An Bord Pleanála,
64 Marlborough Street,

Re: Objection to the Proposed 110kw Electricity Substation at Moyvannan and approximately 6.5km underground electricity cables (ABP-319042-24)

Drawing Title:
**FIGURE 6.1: SITE LAYOUT PLAN 1 OF 2
(1:500)**

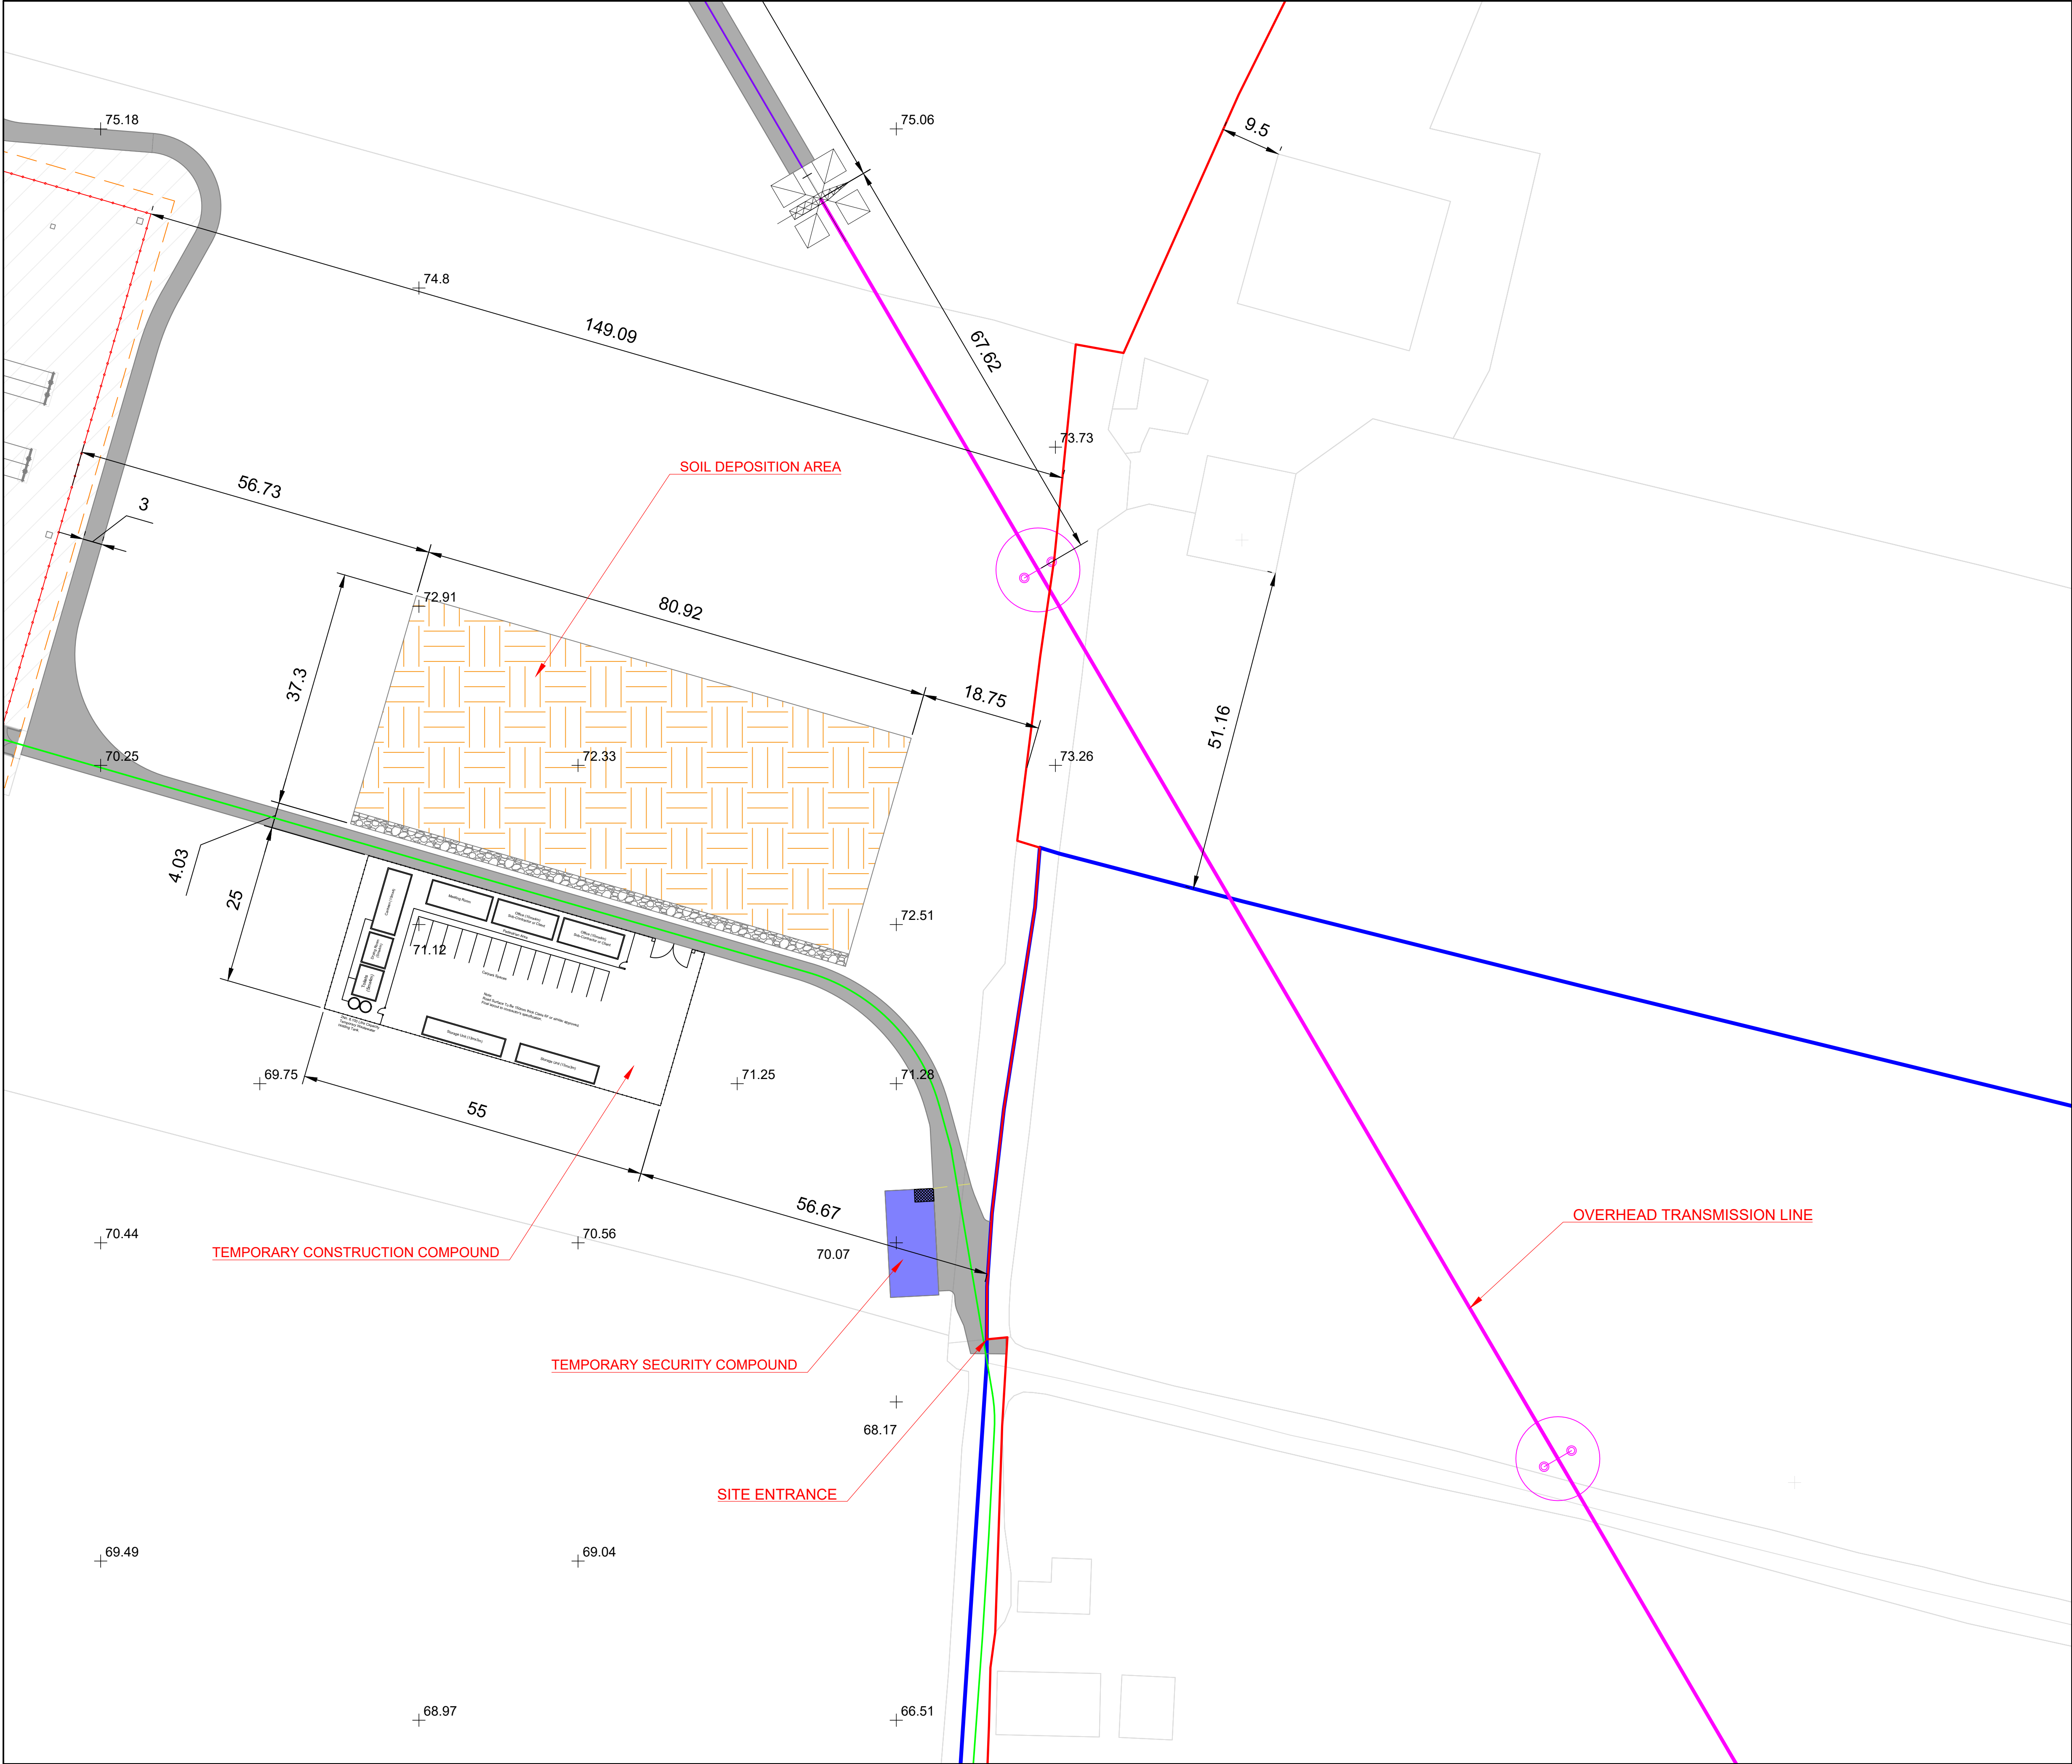
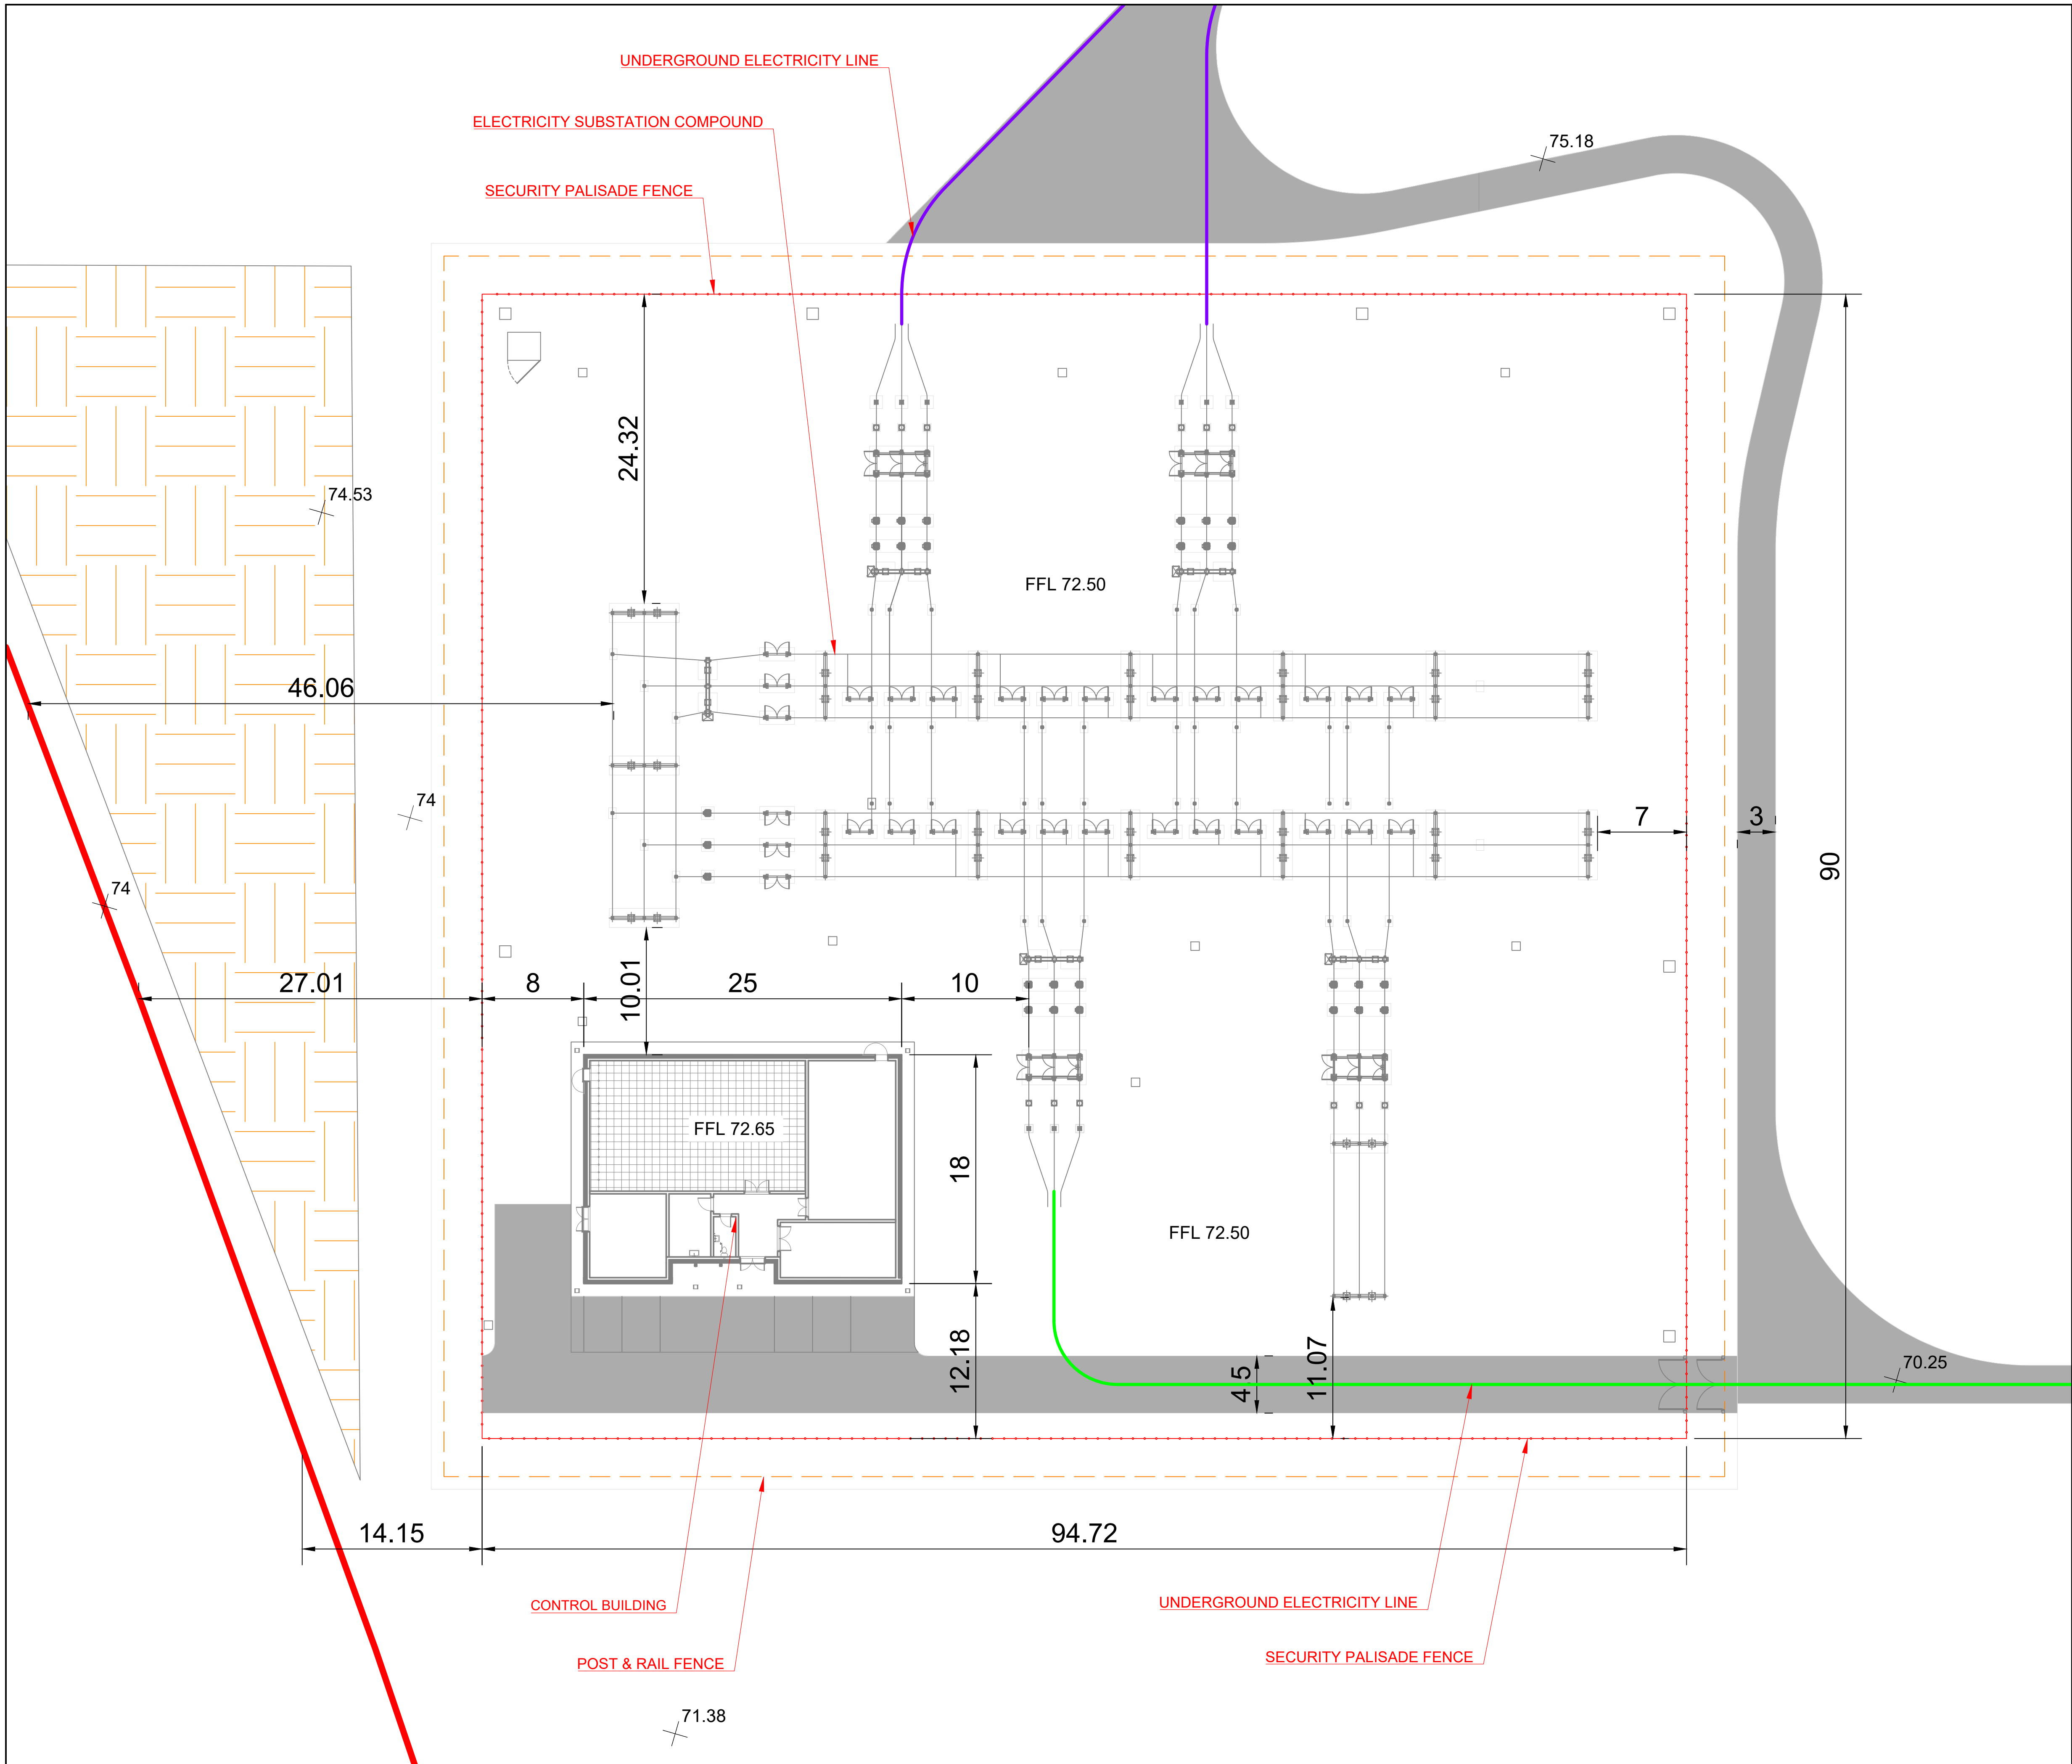
vehicles up L7551 and we have constantly had issues with delivery trucks refusing to deliver given the narrow and unsuitable roads. As such, the proposed development raises several critical concerns regarding the safety of both pedestrians and road users. Visibility splays of 70 meters in both directions are planned, but no upgrades or widening of the road are included in the development plan.

The proposed substation near the L7551 presents significant concerns regarding the safety and practicality of the road infrastructure. The L7551 is a narrow, single-lane road that lacks sufficient space for vehicles to safely pass one another. (See image 3 below that shows how narrow the roadway is). With no designated areas for vehicles to pull in or pass, the addition of construction traffic and maintenance vehicles associated with the substation could lead to hazardous situations. In particular, the limited width of the road could result in congestion, delays, and potential accidents, especially if large vehicles are required to access the site. This situation is made worse by the lack of alternative routes or turning areas, further complicating any effort to manage oncoming traffic. The planning document submitted refers to an estimated 3,714 HGV journeys during the construction phase.

We request that a comprehensive Traffic Impact Assessment be conducted, including a commitment to road widening and safety upgrades before construction begins. Without such measures, the development risks significant disruption and danger to residents.

Given the road's limited width, the absence of proper shoulders, and its potential vulnerability to damage from heavy vehicles, it would be necessary to carry out significant upgrades to ensure that it can safely accommodate such traffic. However, there is no indication that such infrastructure improvements are included in the planning proposal. Without these upgrades, the road would remain unsuitable for the heavy construction traffic that would be generated by the substation.
